Subject: RE: EP/40/12 _ 115-116 Sea Road, East Preston

Peter Cleveland MSc | Senior Planner, Planning Department, Arun District Council | Location: 2nd Floor, Arun Civic Centre, Matrasiers Road, Lymington, BN17 5LP

We submitted an application for 9 number flats at 115-116 Sea Road, East Preston, application number EP140/12.

number: 3279/P201 rev: D  
dm: agw chkd: ge appd: ge

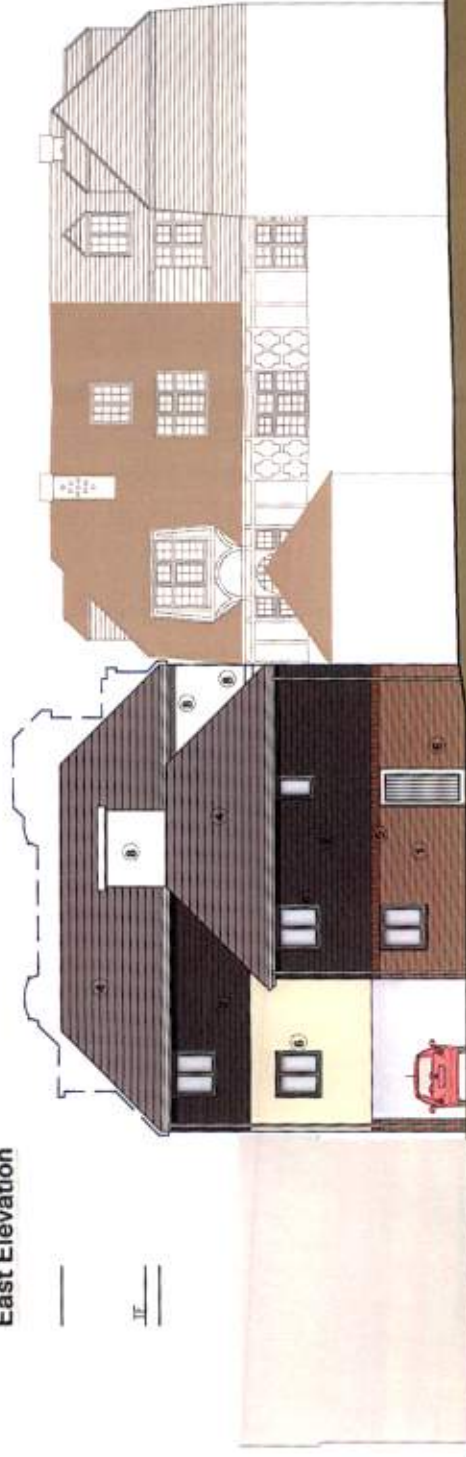
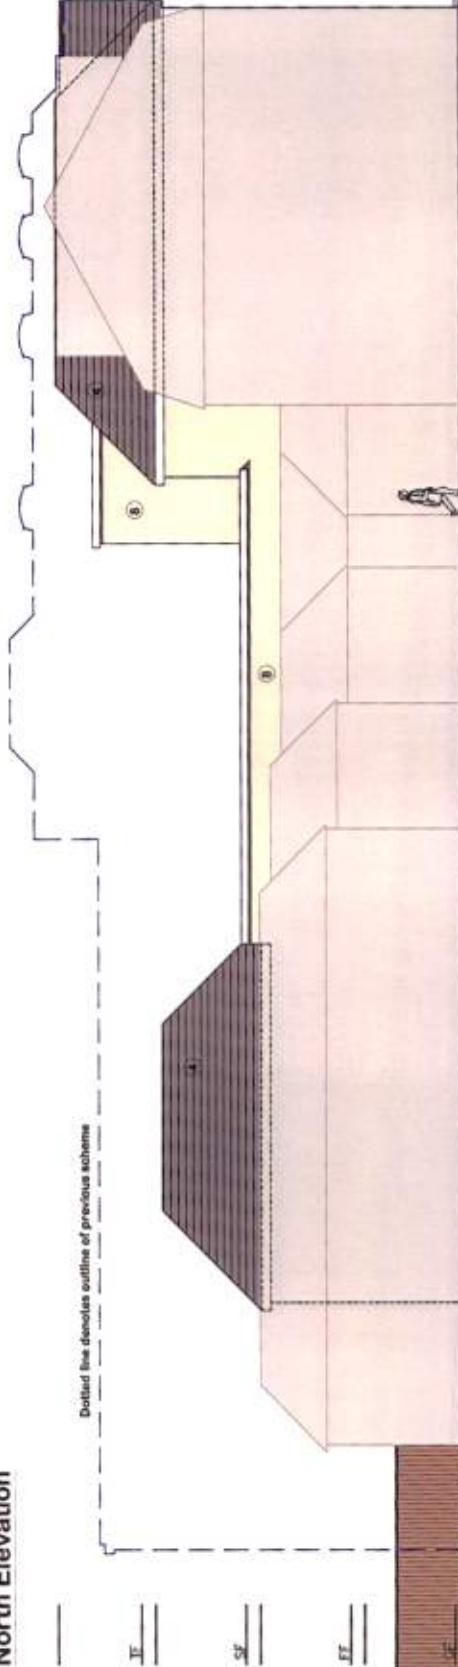
Further to our telephone conversation regarding the email below, I can confirm that the revised design would be more in-keeping with the neighbouring buildings and therefore would request that you submit a revised drawing to that effect to substitute the existing plan on file.

With regards to design I agree that this needs to be revised as the proposed structure when viewed from Sea Road in context with the Parade Mansions is currently not in-keeping. Parade Mansions are noted for their various use of materials with horizontal detailing and changes of material. Parade Mansions are also listed within the Councils local list of character buildings. The proposed structure varies to this with the introduction of vertical changes of materials. This I believe results in a building which is not in-keeping with the street scene and therefore at present detracts from the locality.

I have updated the front (West) elevation as per our discussions and have also updated the South and East elevations to carry the render around the corner. This is now more in-keeping with the neighbouring buildings.
